RE: Family Dollar
1400 Gibson Blvd SE
Grading Plan
Engineers Stamp Date: 5/11/18 (L15D049)

Based on the information provided in your submittal received on 5/11/18, the grading plan cannot be approved for building permit until the following are addressed:

FAMILY DOLLAR STORE
GRADING & DRAINAGE PLAN

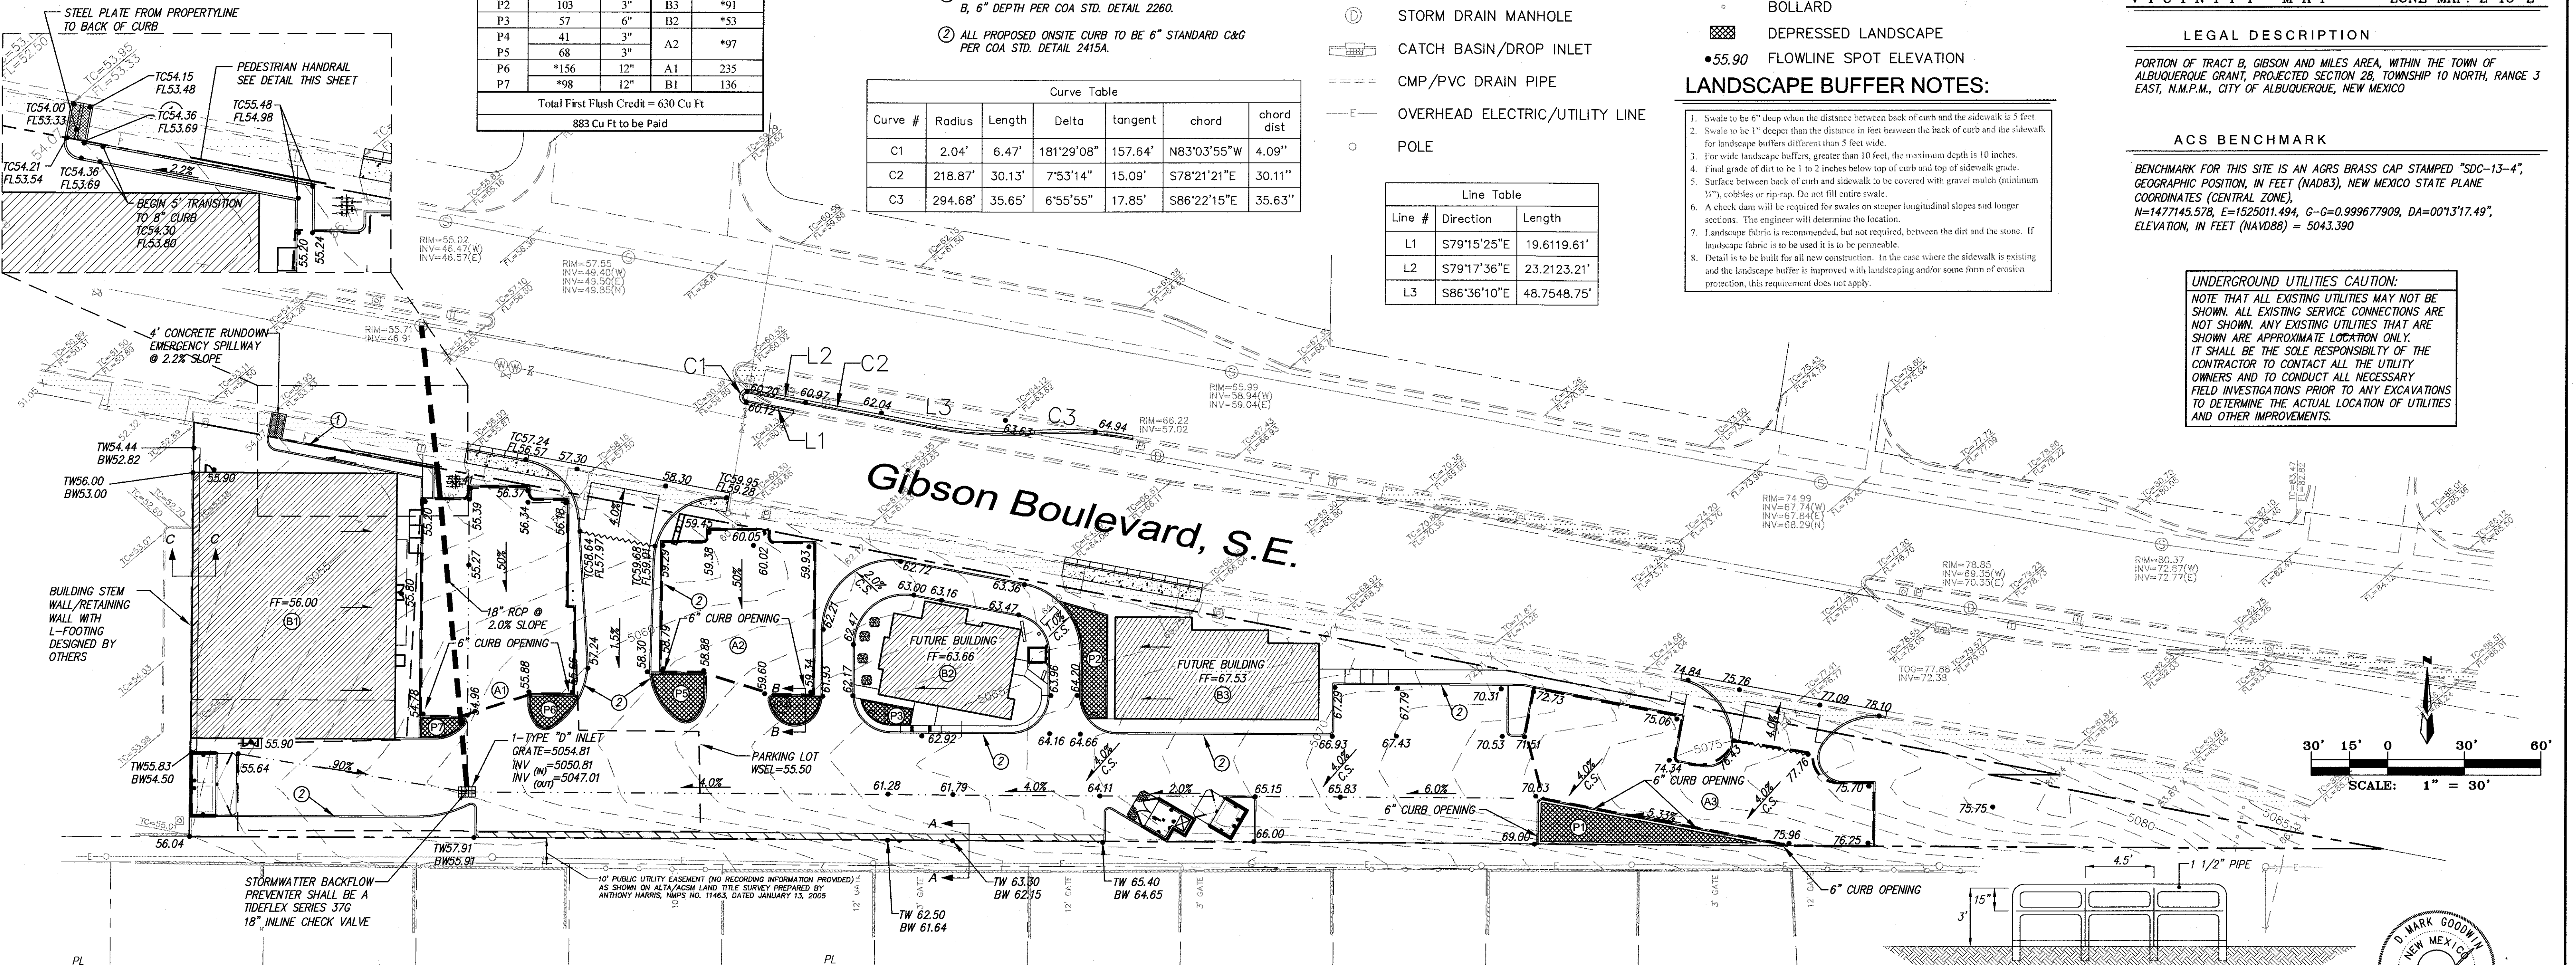
1. A Private Drainage Covenant (no Public Easement) is required for the backflow preventer. The original notarized form, exhibit A (legible on 8.5x11 paper), and recording fee (\$25, payable to City of Albuquerque) must be turned into DRC (4th, Plaza del Sol) for routing. Please contact Charlotte LaBadie (clabadie@cabq.gov, 924-3996) or Madeline Carruthers (mtafoya@cabq.gov, 924-3997) regarding the routing and recording process for covenants.

2. A Private Facility Drainage Covenant is required for the stormwater quality ponds. The original notarized form, exhibit A (legible on 8.5x11 paper), and recording fee (\$25, payable to City of Albuquerque) must be turned into DRC (4th, Plaza del Sol) for routing. Please contact Charlotte LaBadie (clabadie@cabq.gov, 924-3996) or Madeline Carruthers (mtafoya@cabq.gov, 924-3997) regarding the routing and recording process for covenants.

3. Payment of the Fee in Lieu (Amount = 883CF x \$8/CF, per grading plan, stamped 5/11/18) for the required first flush volume must be made. Include a copy of the paid receipt with your resubmittal.
